Title	Deadline 2 Noise Responses		
Project	Gatwick Airport DCO		
Reference	28AD.NT.3.0	Author(s)	BHo
Date	9 April 2024	Reviewer	VC

ExA's Written Questions (ExQ1)

REP2-005 – Applicant's responses to ISH5

Diagram 7.4.1: Distribution of Additional Awakenings due the Project in 2032 Versus 2032 Baseline, Slow Transition Fleet

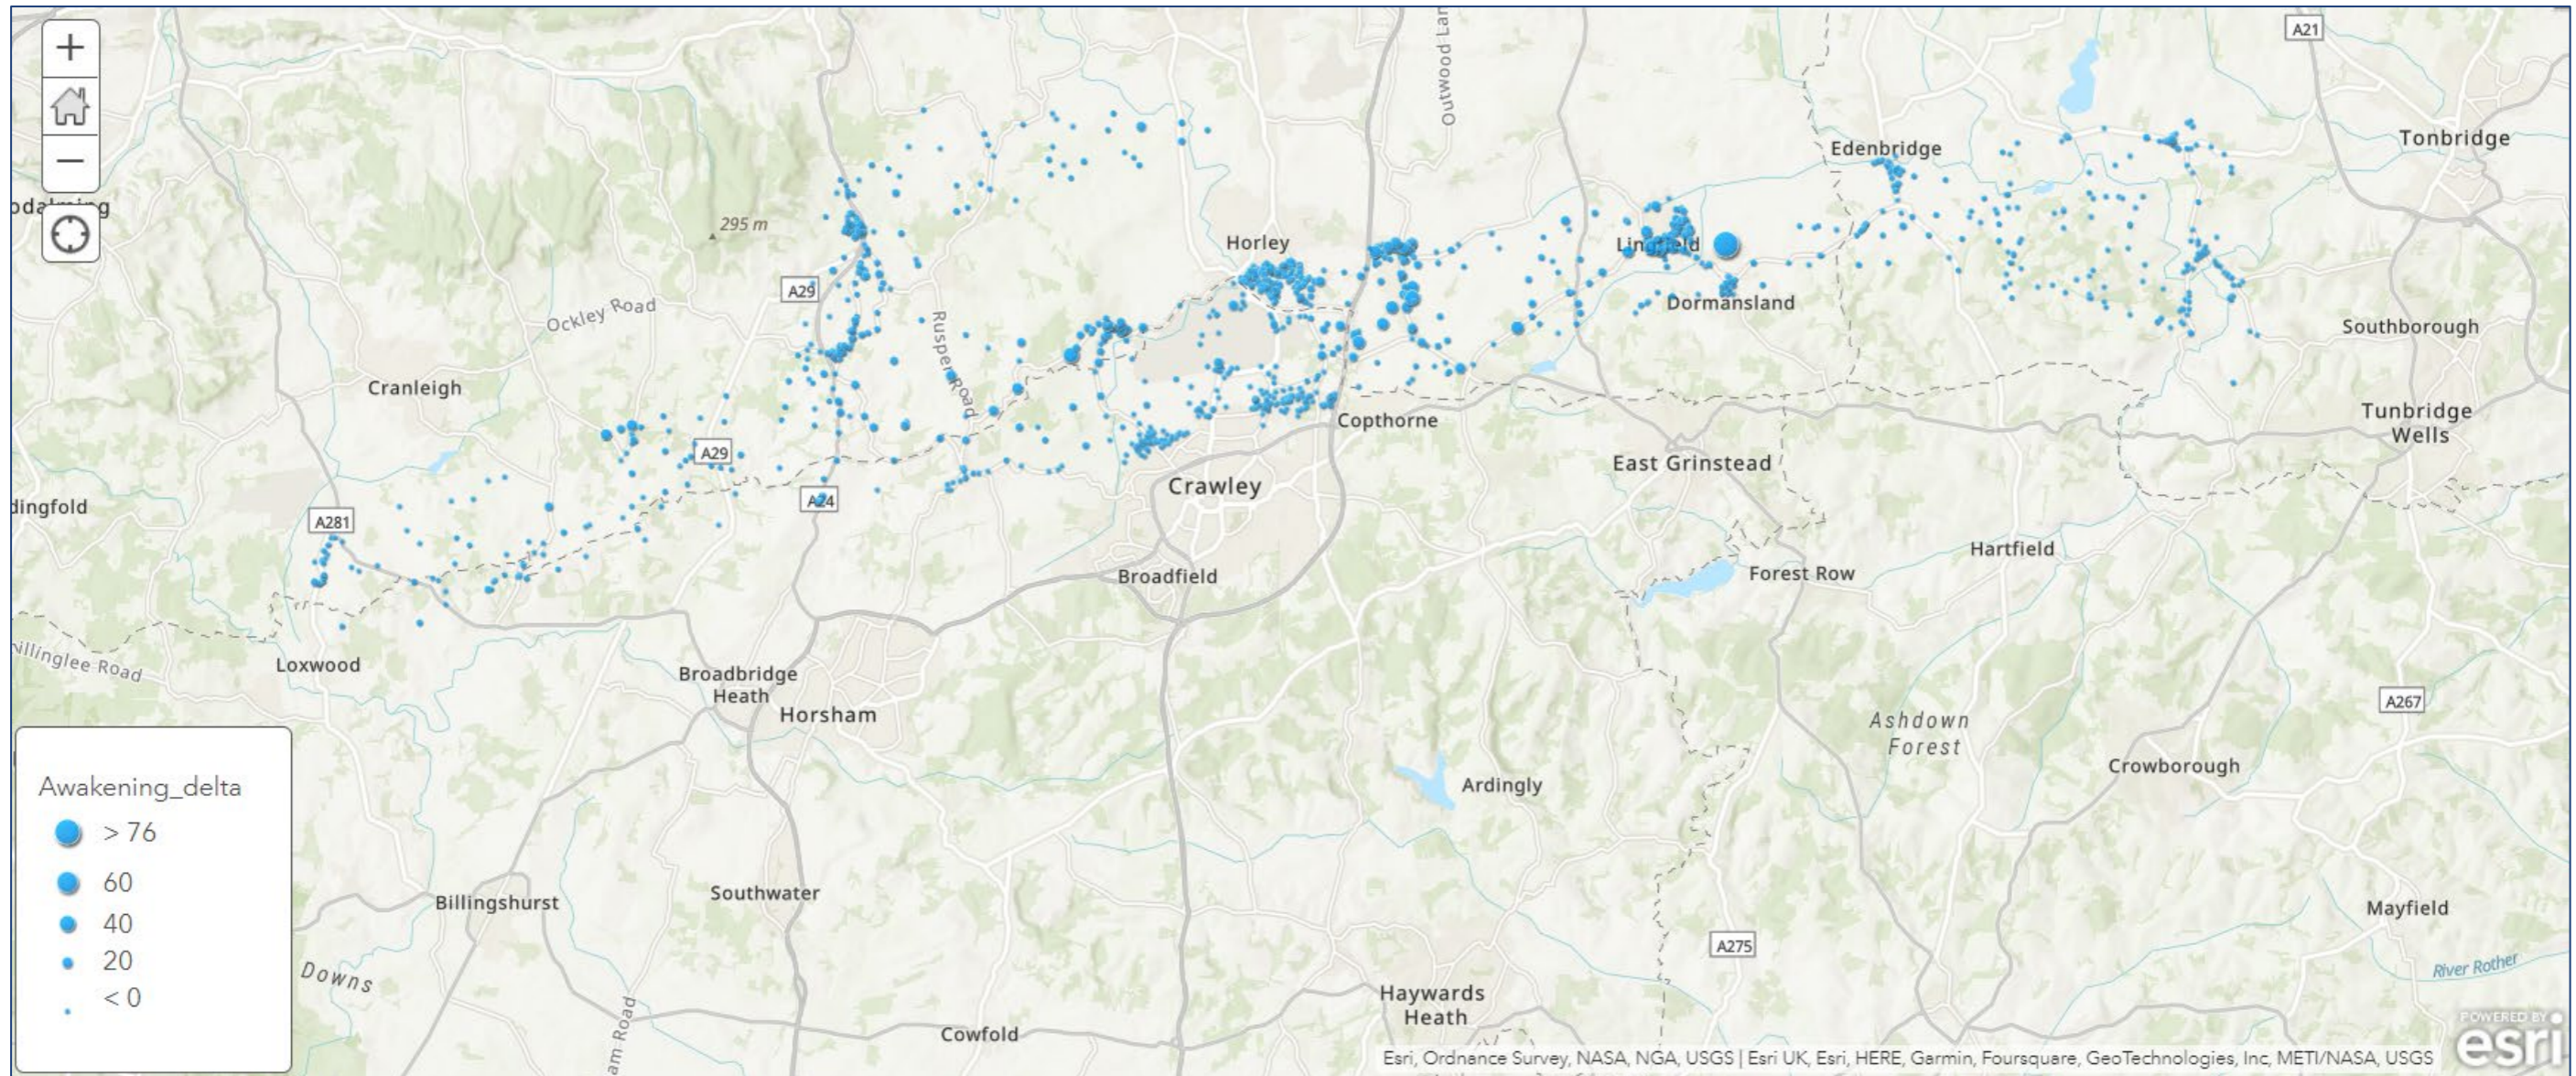
6. We have commented previously that we would expect the Heathrow PEIR thresholds of significance to be accounted for. It is not clear why the Applicant is disregarding the Heathrow application. We note that the Applicant relies on the Heathrow PEIR in its position on other matters and therefore note the contradiction in this instance.

8. The Applicant has not selected UAELs for the day or night. It has also not justified its position of comparing against Heathrow's UAELs. For the Applicant to state that it places no weight on awakening thresholds taken from the Heathrow PEIR is not accepted as justifying the approach taken for awakenings and a full assessment involving appropriate methodology and criteria should be requested by the ExA.
